Subject: Land East Of Roundstone Lane Angmering BN16 4AL - A/43/22/PL

Proposal: Variation of condition following grant of A/3/21/PL relating to Condition No 1 - approved plans.

Location: Land East Of Roundstone Lane Angmering BN16 4AL

External Lighting Services
General & Decorative Lighting
Front & Rear Layout
Title 4

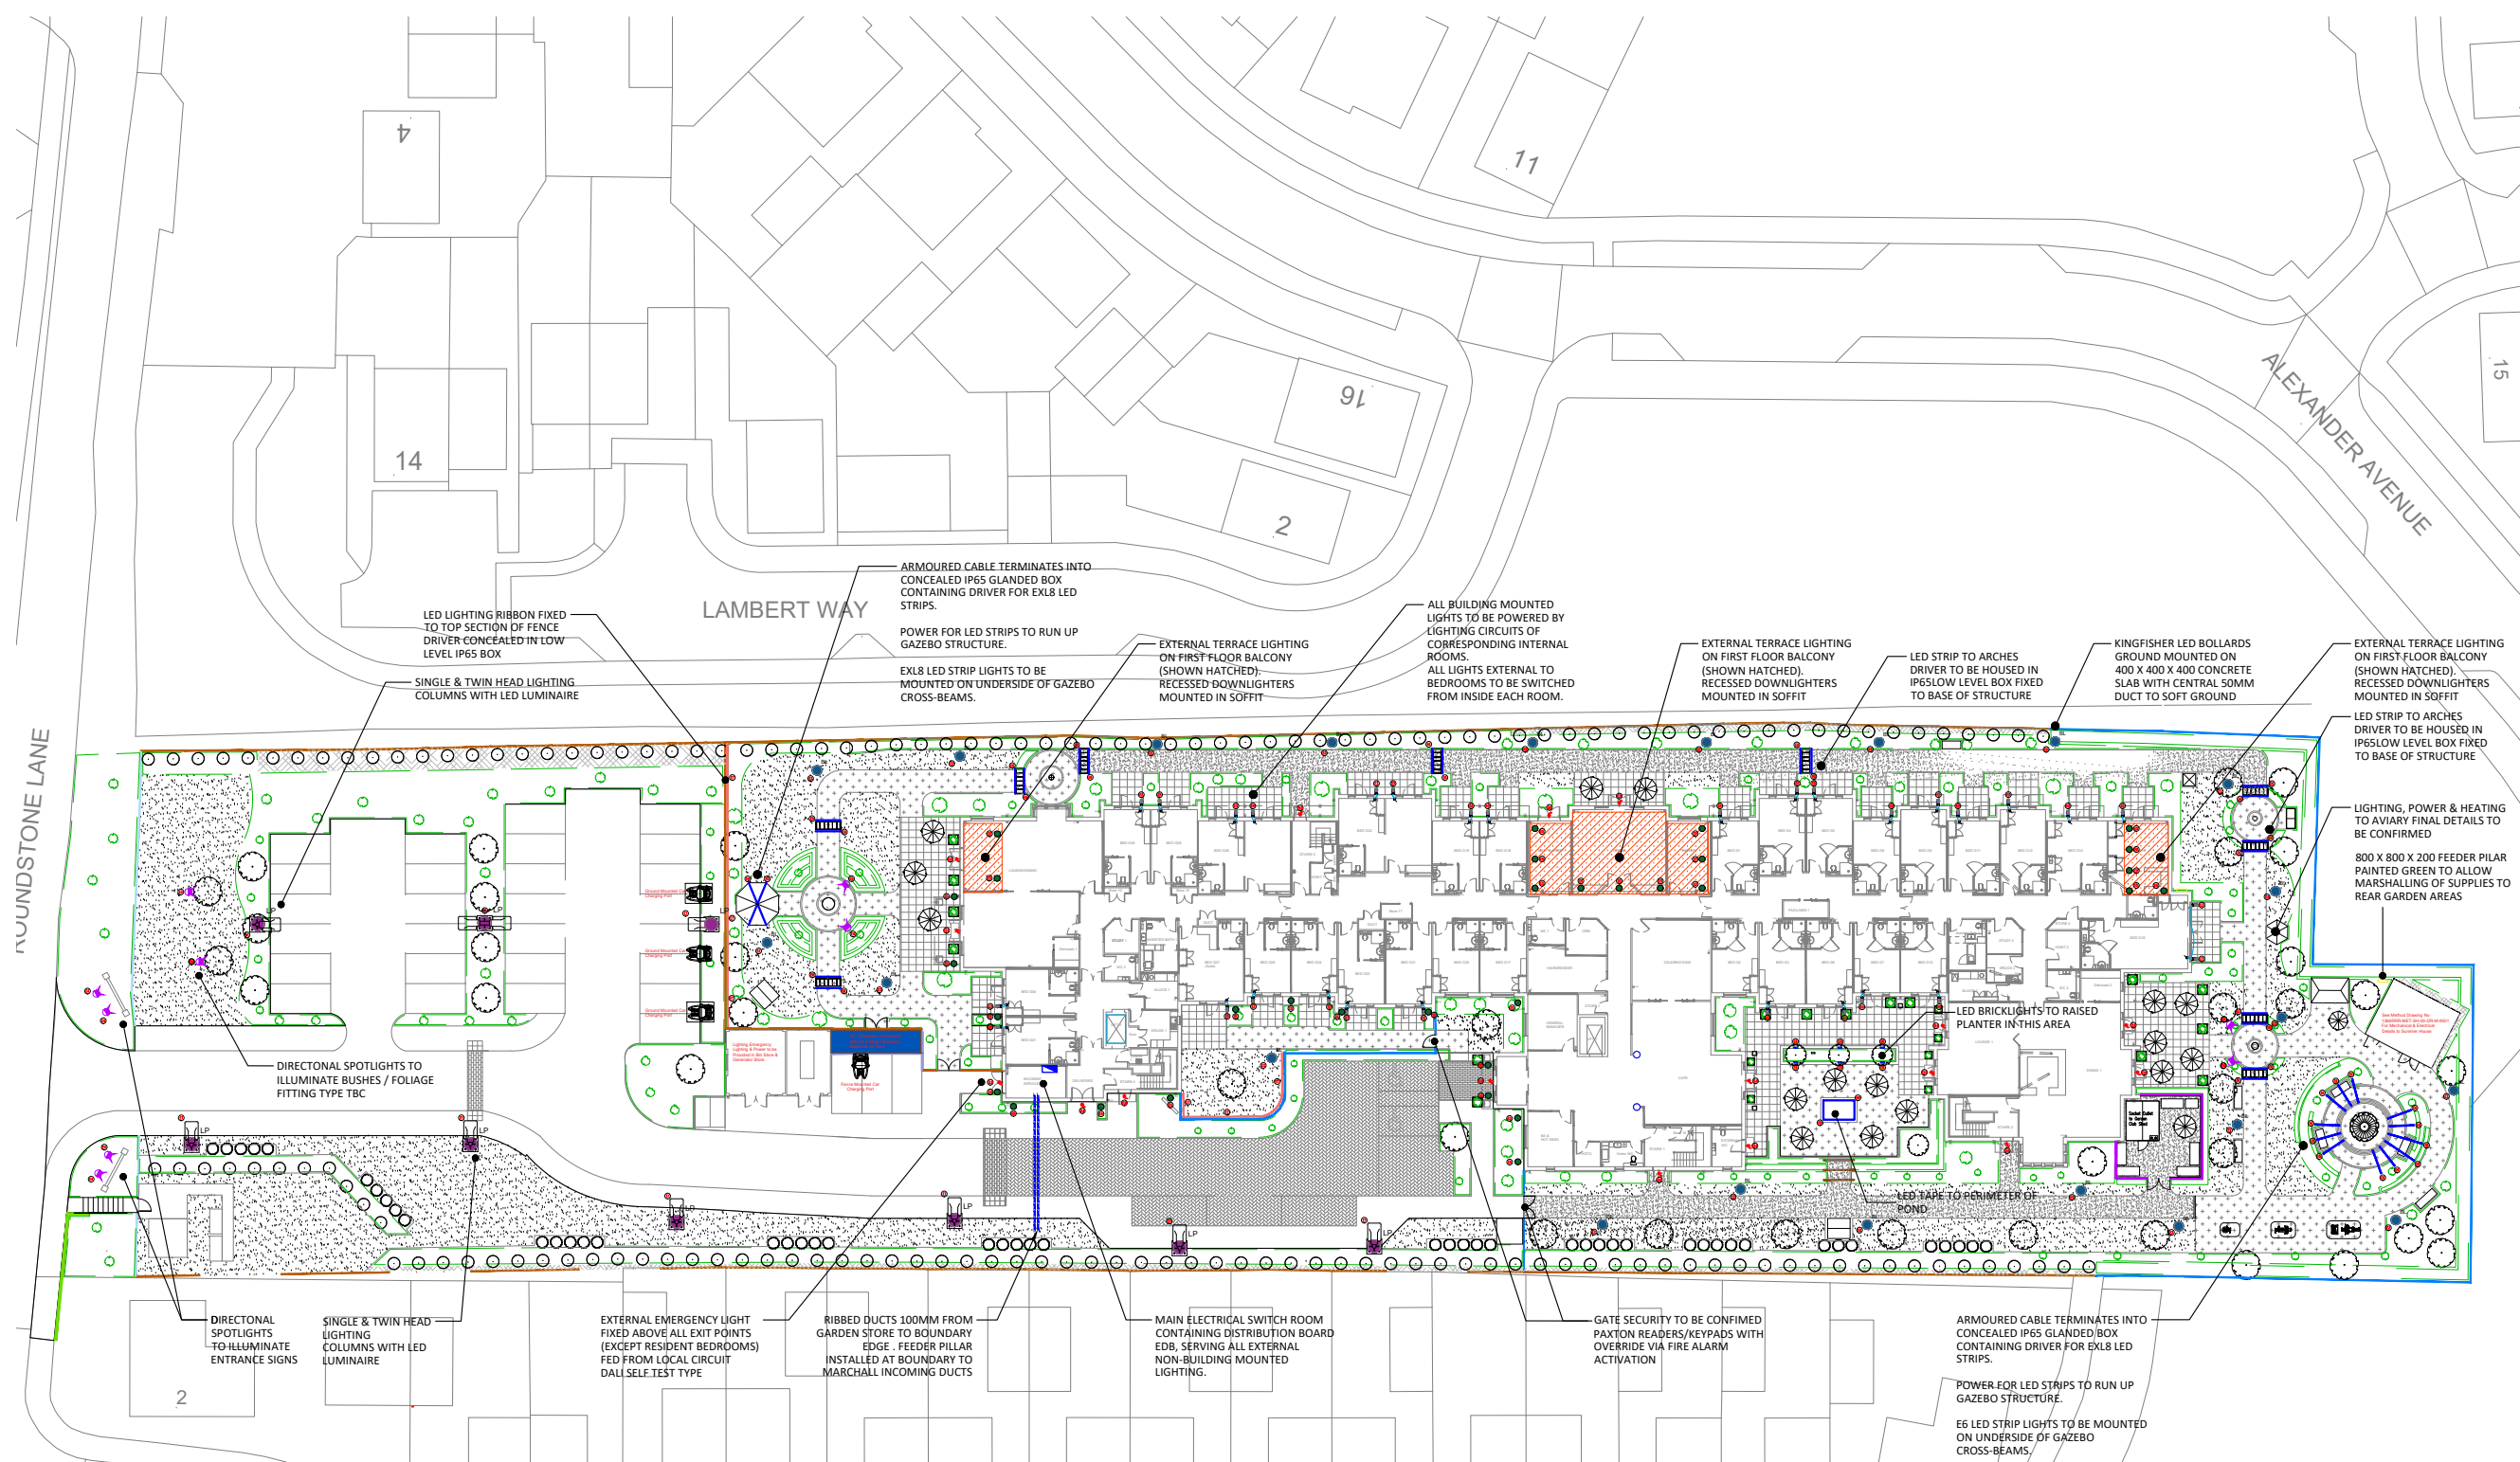
Condition 4 – External Lighting

Having reviewed the document entitled 'External Lighting Dwg No D41414/PMU/A' (dated 13 November 2020) [produced by Kingfisher Lighting] I can confirm that the information provided is satisfactory and therefore recommend the condition may be discharged.
